**WMDC HIGHWAY DEVELOPMENT MANAGEMENT (HDM) RESPONSE ON
PROPOSED DEVELOPMENT**

APP. REF: 23/00020/S7301

LOCATION: Land At Whistler Drive, Castleford

DESCRIPTION: Variation of conditions 2 (approved plans), 7 (Drainage Strategy), 9 (Operating Hours), 11 (Electric Vehicle Charging), and 28 (Bat and Bord Box Provision) to facilitate amendments to the design and layout of the approved erection of 4no. B2/B8 Blocks together with external works and landscaping, and creation of a substation and meter rooms approved on 20.10.2023 and as amended through non-material change applications 23/00020/NMC01 (Amended of condition 23 wording) approved on 10.11.2023 and 23/00020/NMC/02 (to remove reference of 30 no. hybrid units from the development description) approved on 22.04.2024.

DRAWING TITLE:
Cycle Store, Bin Store and Meter Room Details

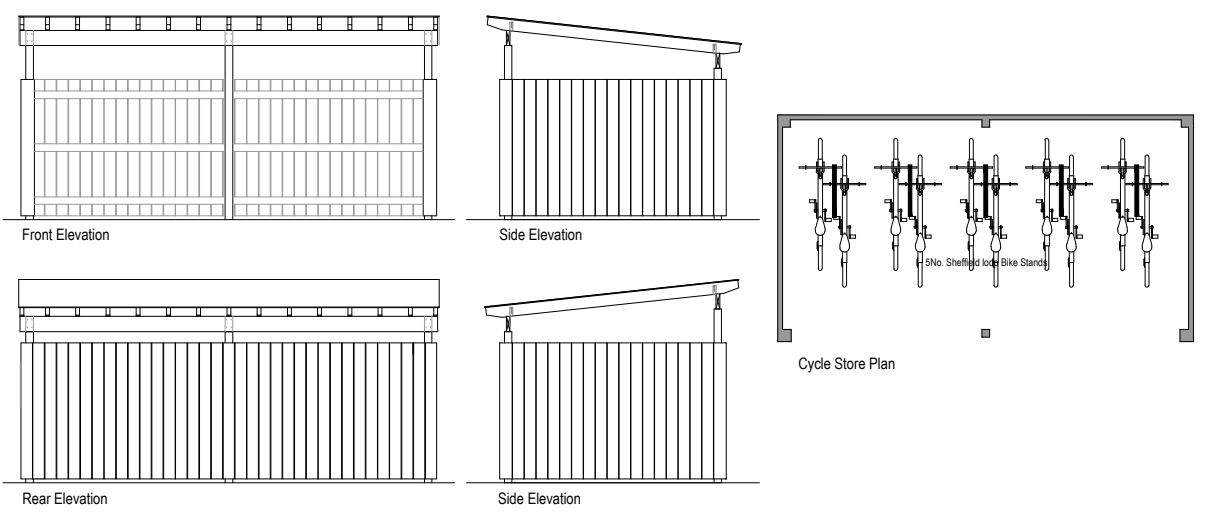
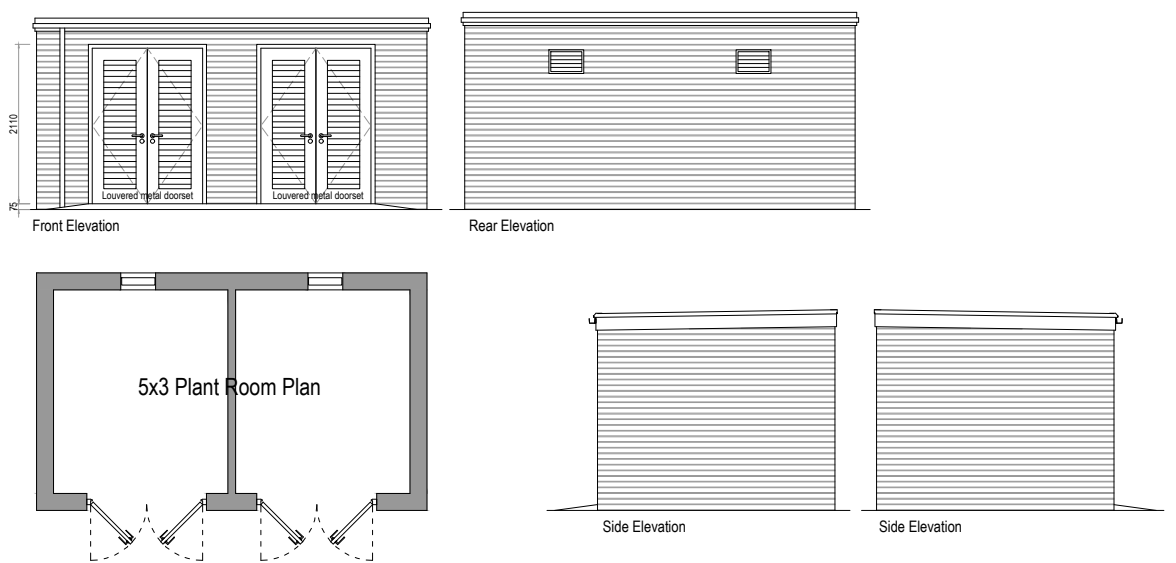
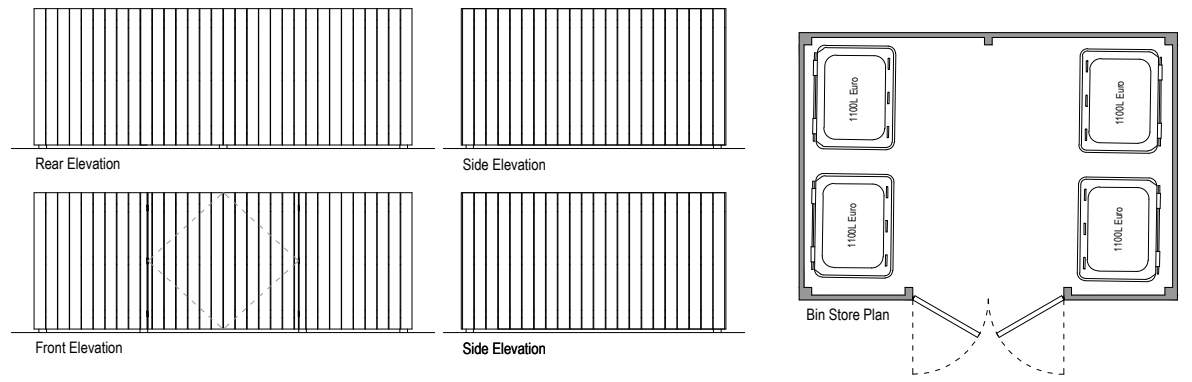
- vi. Other than unit 1, each would have enhanced service vehicle parking internally due to the increase in length and height from the ground floor.
- vii. 30 cycle parking spaces are to be provided within three stores exceeding the minimum requirement of 23 spaces based on one space per 150sqm for B2 uses in the WSDG SPD.

- viii. Cycle storage units are adequate.
- ix. There is space for bin storage.
